Thanet Extension Offshore Windfarm

Planning Inspector Reference: EN010084

**Natural England's Comments on Other Written Representations Submitted at
Deadline 1.**

5th February 2019

Figure 2.7b (2 of 9) Aerial Maps - Option 2

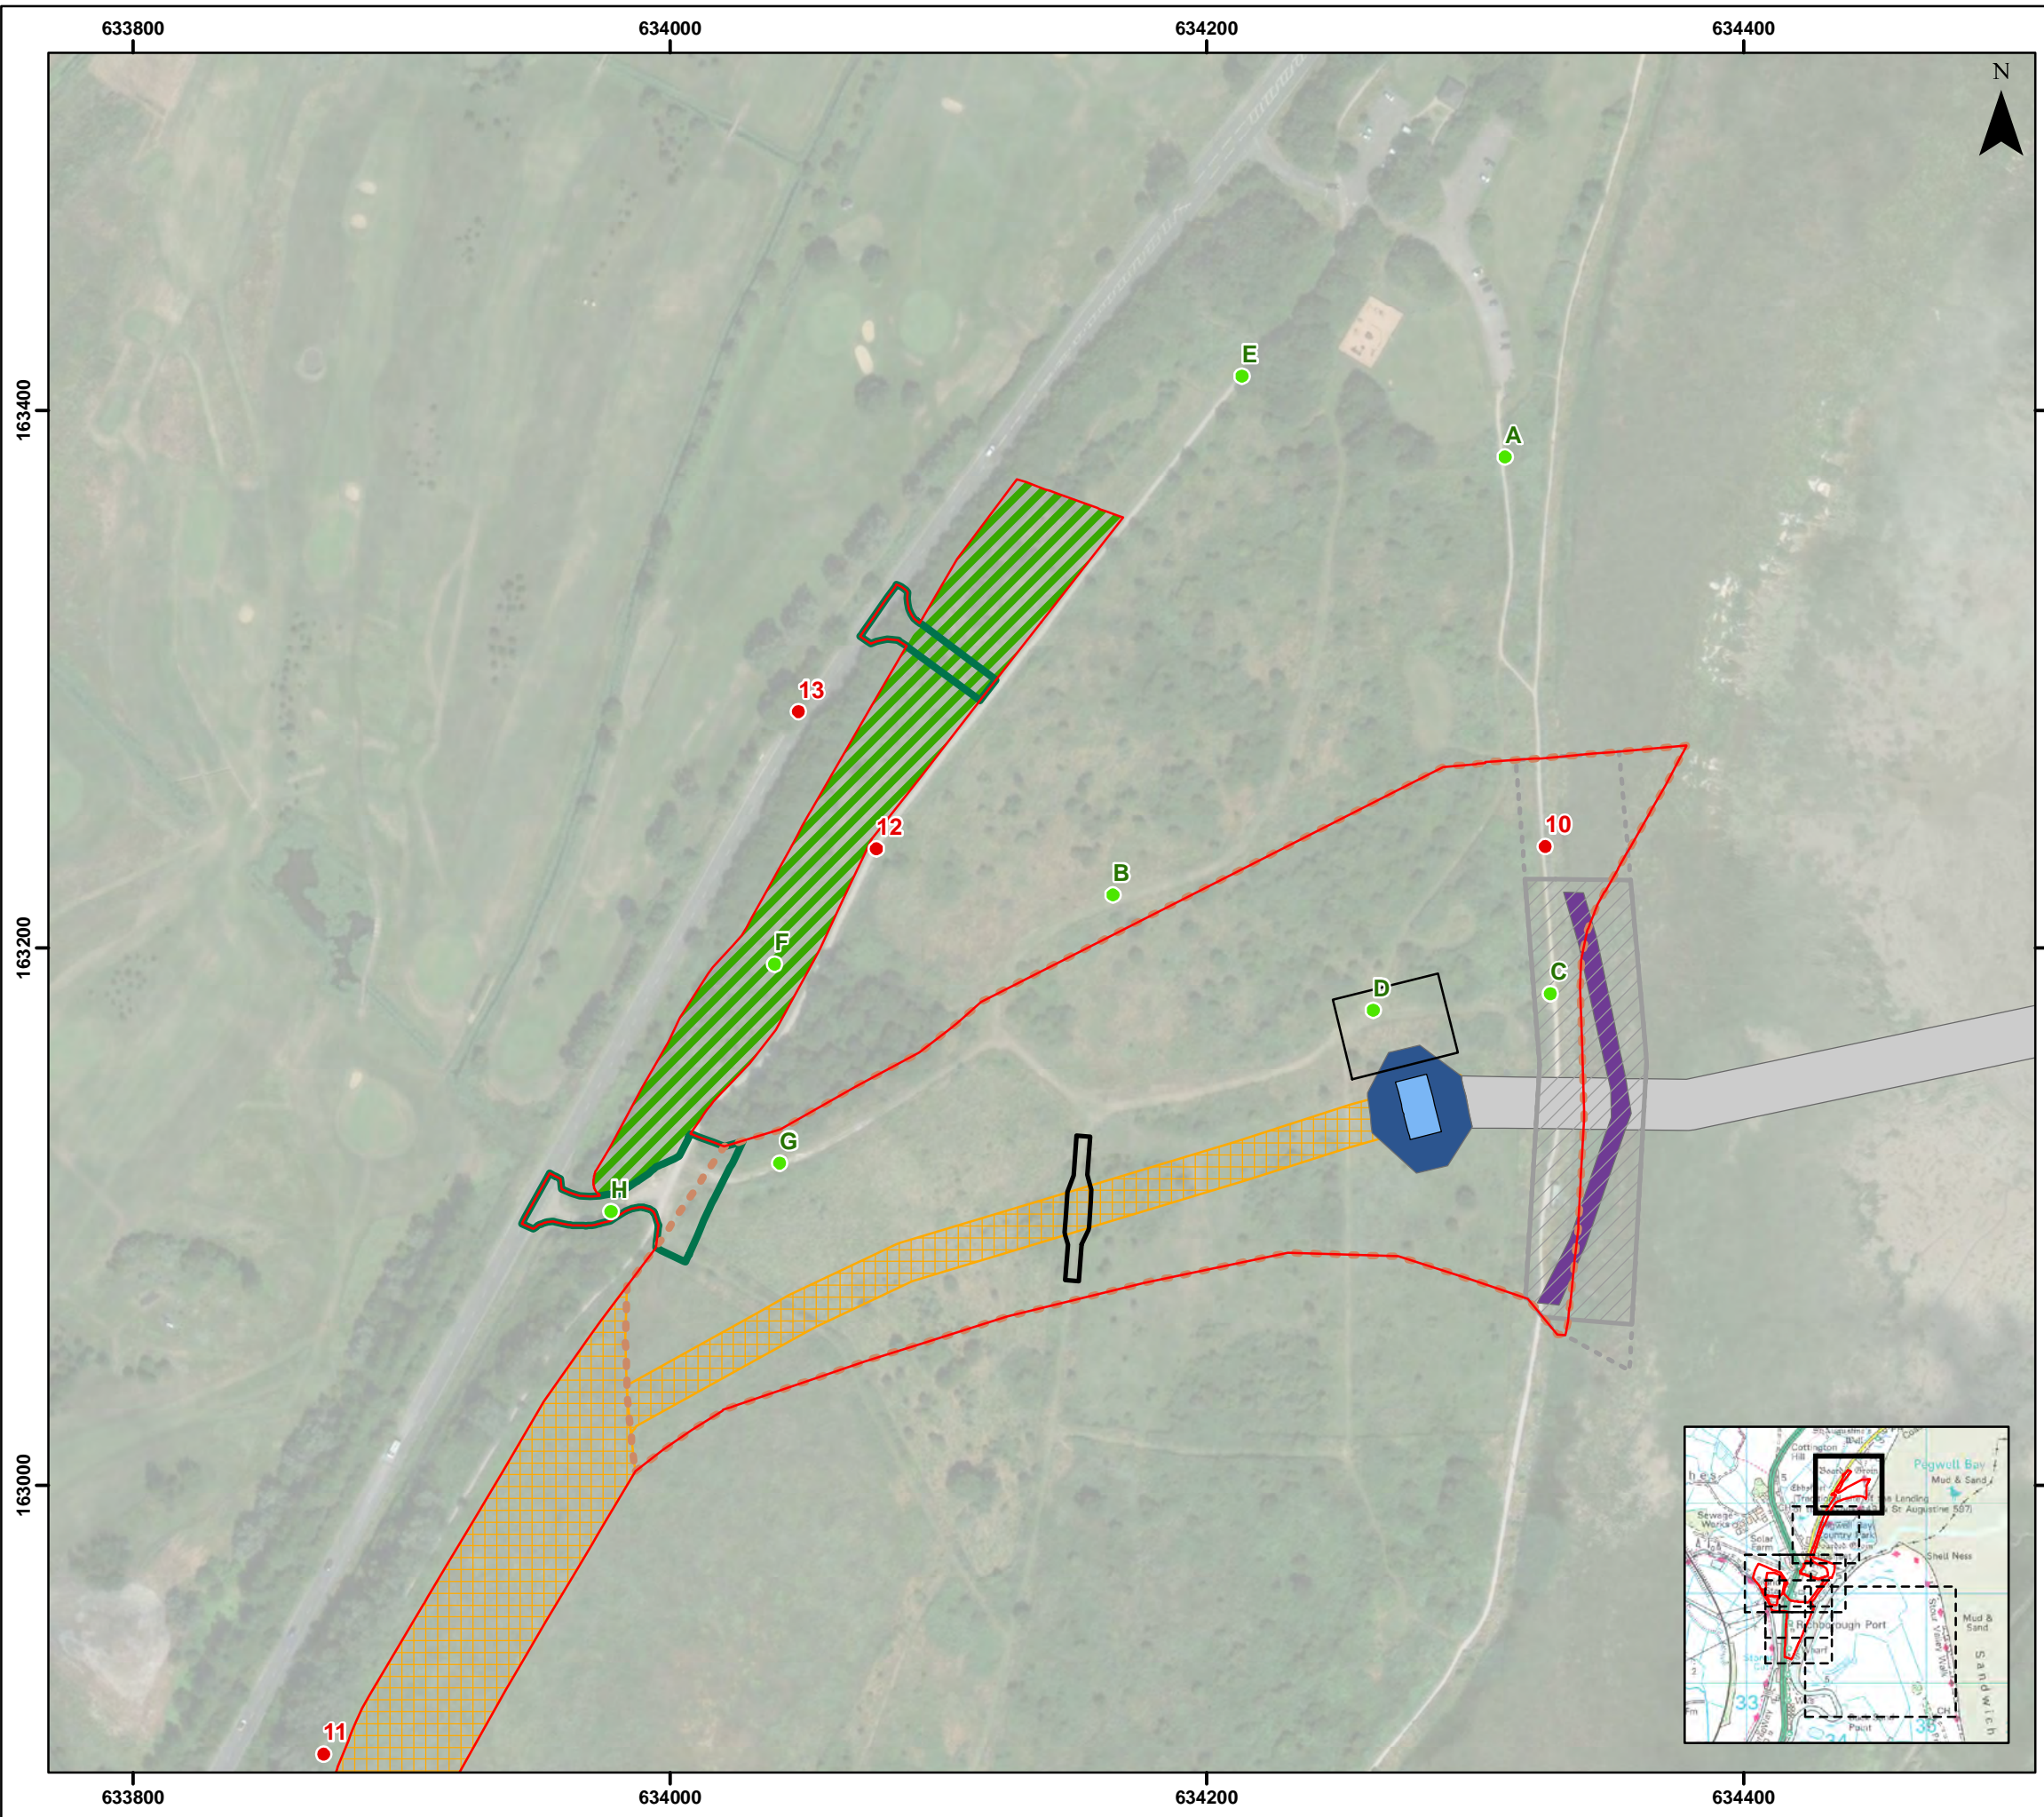
are not entirely clear about the extent of land to be acquired and as such the NT objects.	
4.1/4.2	The developers have indicated physical alterations which might affect the area of onshore land, adjacent to the rock armoured sea wall, including installing a Transition Pit and extending/altering the sea wall. NT not been provided with detail and thus objects to any proposed alterations, additions or changes to this land or the sea wall or any acquisition of the Trust's land.	Slightly related to Natural England's position. Natural England have raised major concerns regarding the extension of the sea wall associated with option 2 and the loss of saltmarsh. However, these concerns have been lessened by the removal of option 2 from the project envelope.

5.1/5.2	An over ground berm is not seen as acceptable, especially in light of the impact from project Nemo on the Country Park. If this were to happen then it would be required a complete landscaping design and options to mitigate impact and create a single structure more in keeping with the rest of the park and the surrounding land.	Natural England defers to KCC, KWT and NT regarding issues upon the country park, However, we are supportive of underground burying of assets within the country park as it allows for greater flexibility at the landfall location.

5.3	The National Trust welcomes Vattenfall's decision to withdraw the above ground Option 2. If the option to underground the cables across the Park are implemented this will significantly alter the impact of the project on the park, its management and users. It is the preferred option and considered to be the only acceptable way to accommodate the project across the Pegwell Bay Country Park.	In line with Natural England's position.
